# CITY OF ALBUQUERQUE

August 9, 2021

Re: **5<sup>th</sup> Street**  
**1715 5<sup>th</sup> St NW**  
**Traffic Circulation Layout**  
Architect's Stamp **NONE** (H14-D100A)

Based upon the information provided in your submittal received **08-05-2021**, the above referenced plan cannot be approved for Building Permit until the following comments are addressed:

Sheet: Traffic Control Layout

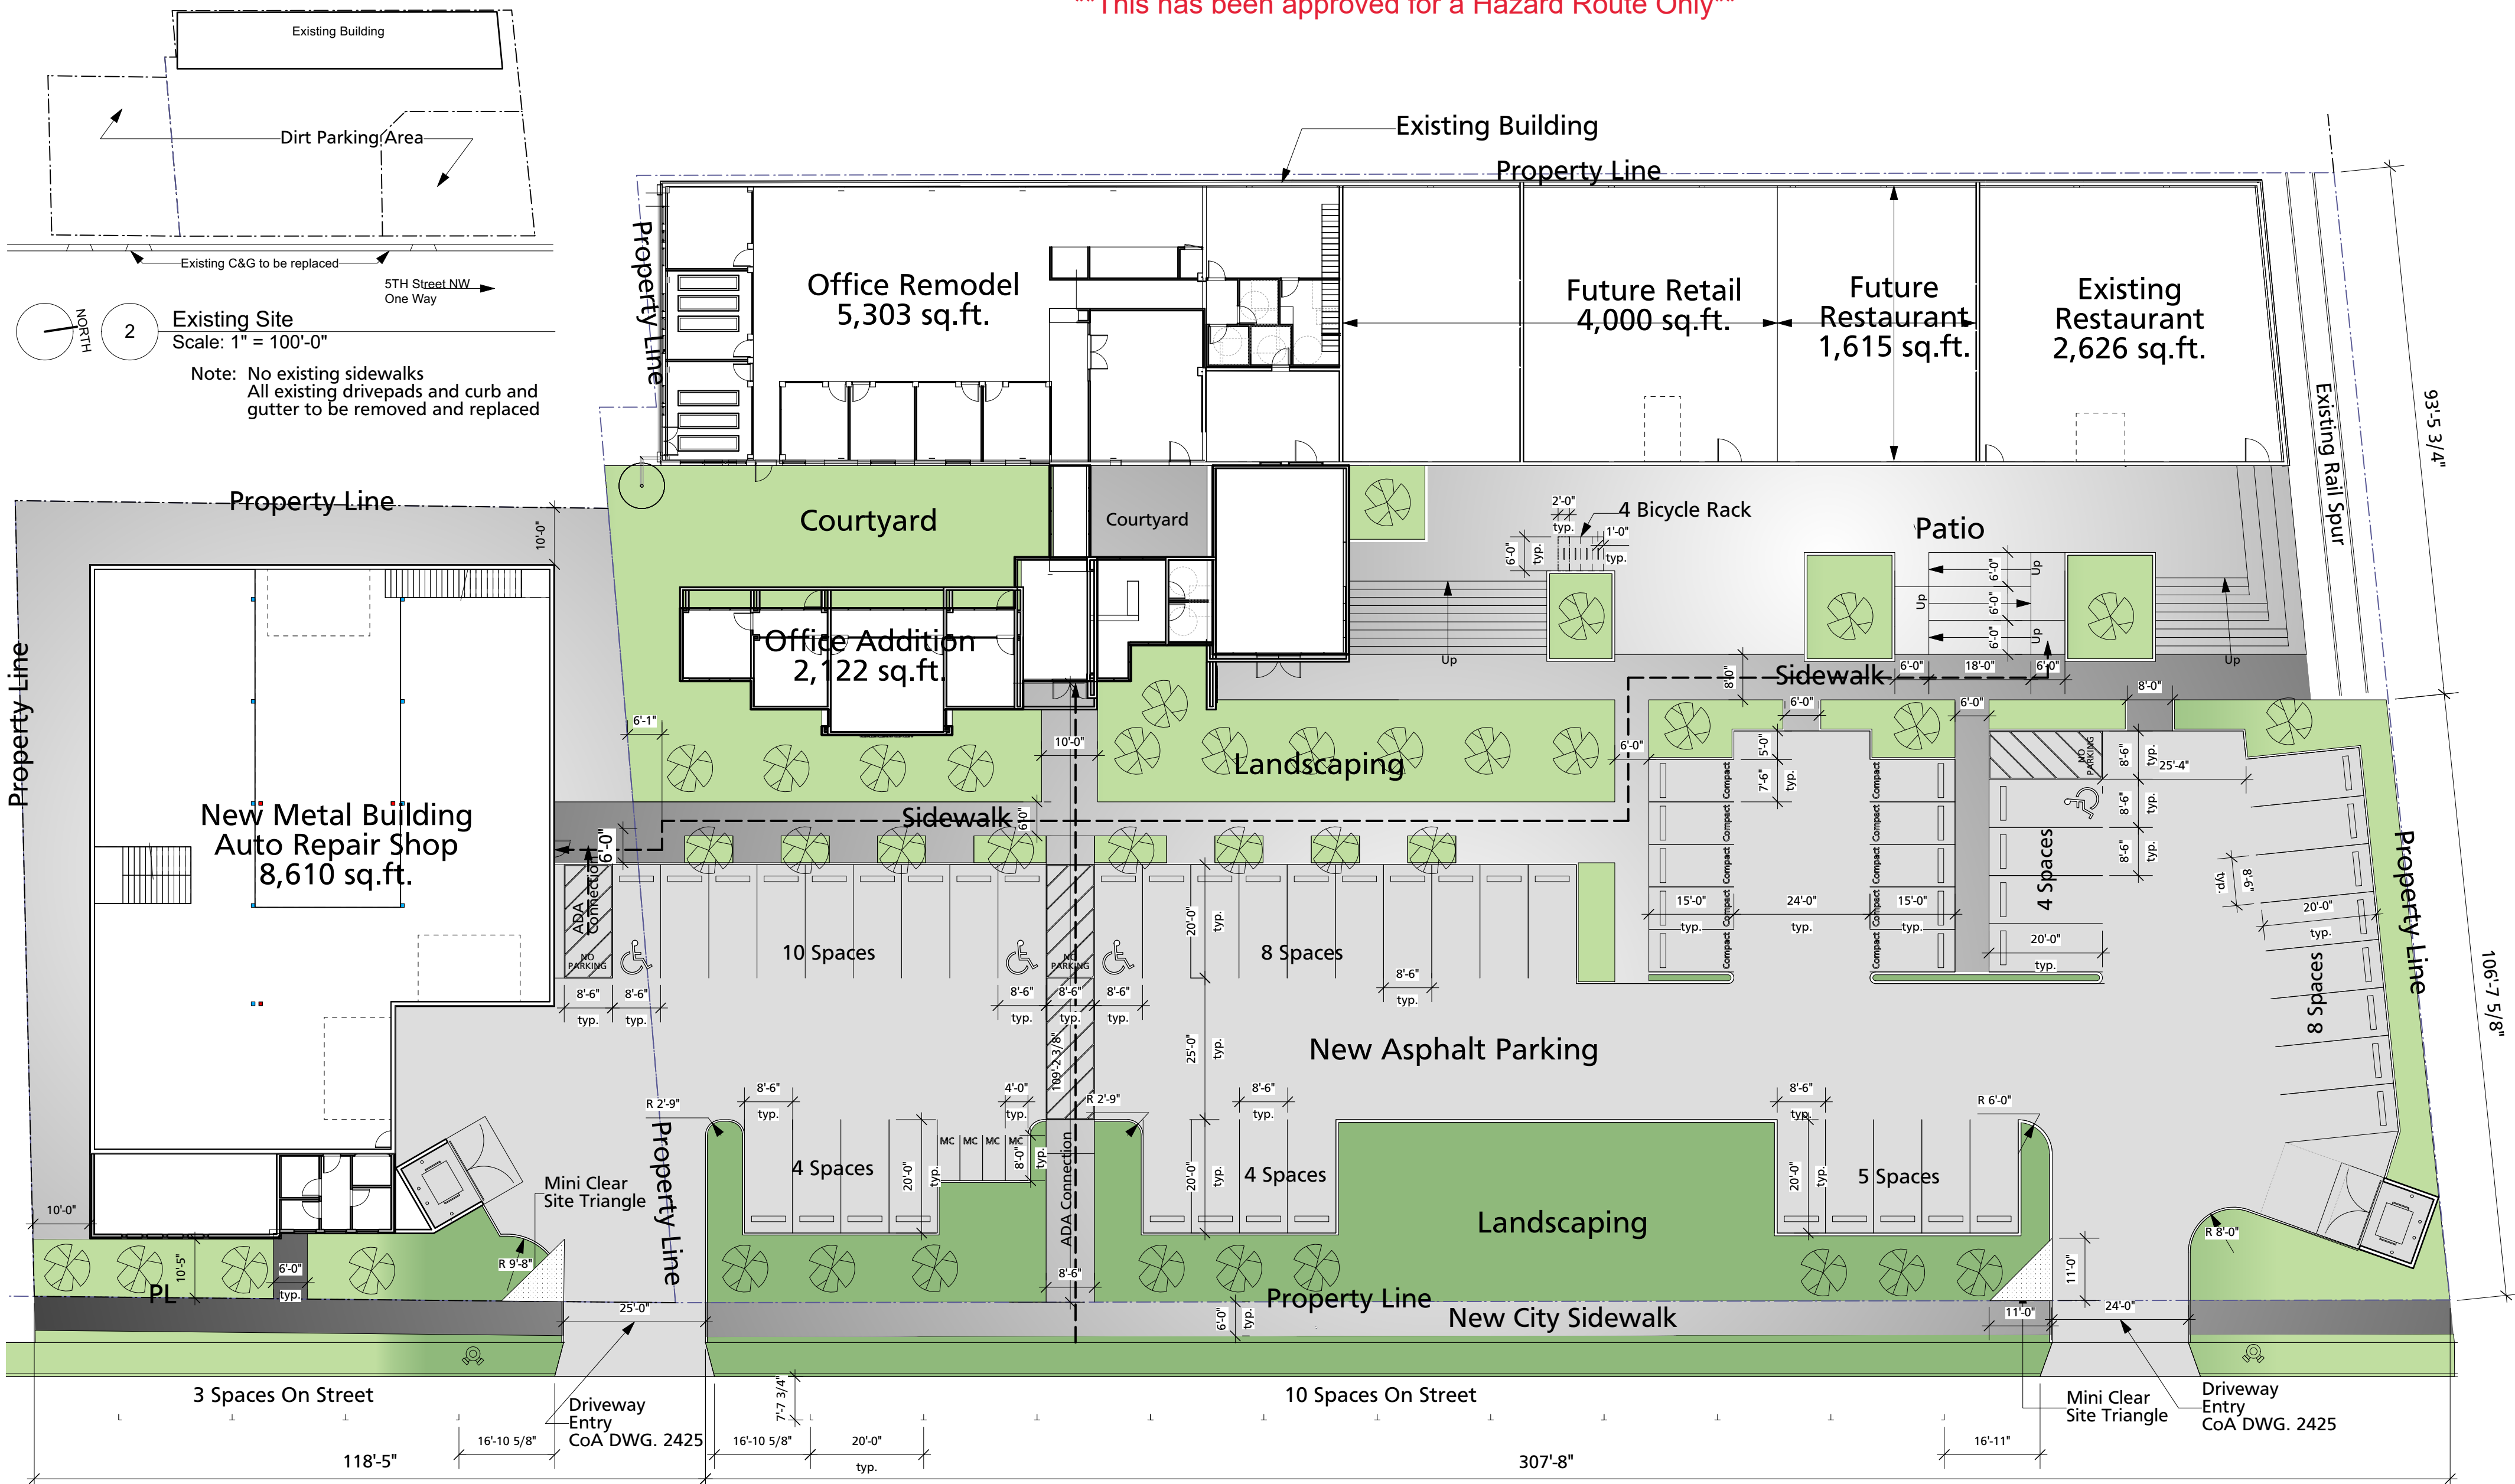
1. **The traffic circulation layout must be stamped, signed, and** dated by an engineer or architect licensed in the state of New Mexico.
2. The title sheet will need to be named **Traffic Circulation Layout** instead of Traffic **Control** Layout. Traffic Control required a different type of submittal with a registered Engineer.

1 Site Plan- Scale: 1" = 20'-0"

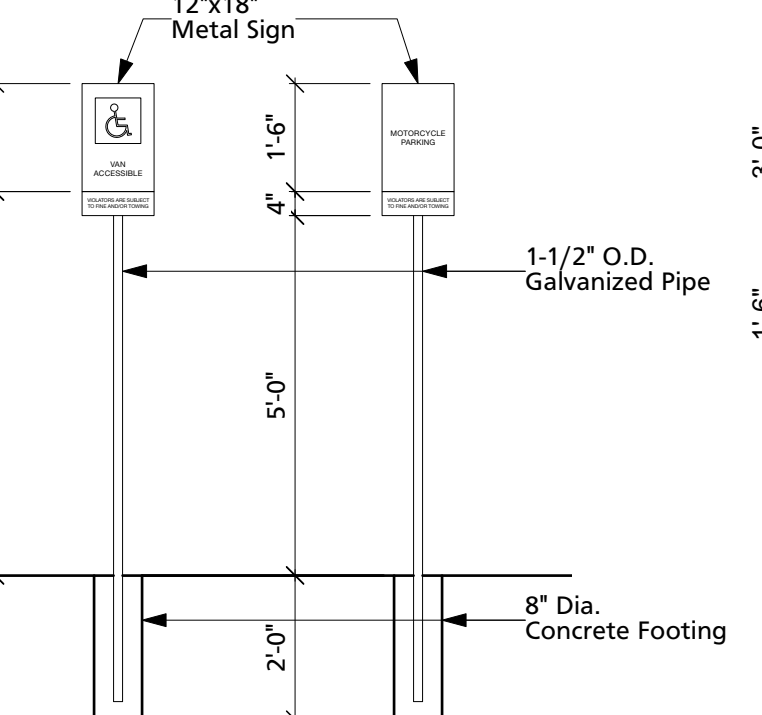
3. **5<sup>th</sup> Street ROW frontage**
  - **A transition back to existing location of sidewalk will need to be provided.** See COA std dwgs to determine which transition needs to be used.

- You have a note specifying that all C & G is to be moved and replaced. **So, reference COA std dwg 2415A for all curb & gutter fronting 5<sup>th</sup> St** if this is your intend.

5. Per the IDO, a 6 ft. wide ADA accessible pedestrian pathway: details. Dimension the proposed pathway. **Provide ADA ramp design for the pathway adjoining the parking lot curb and gutter.**
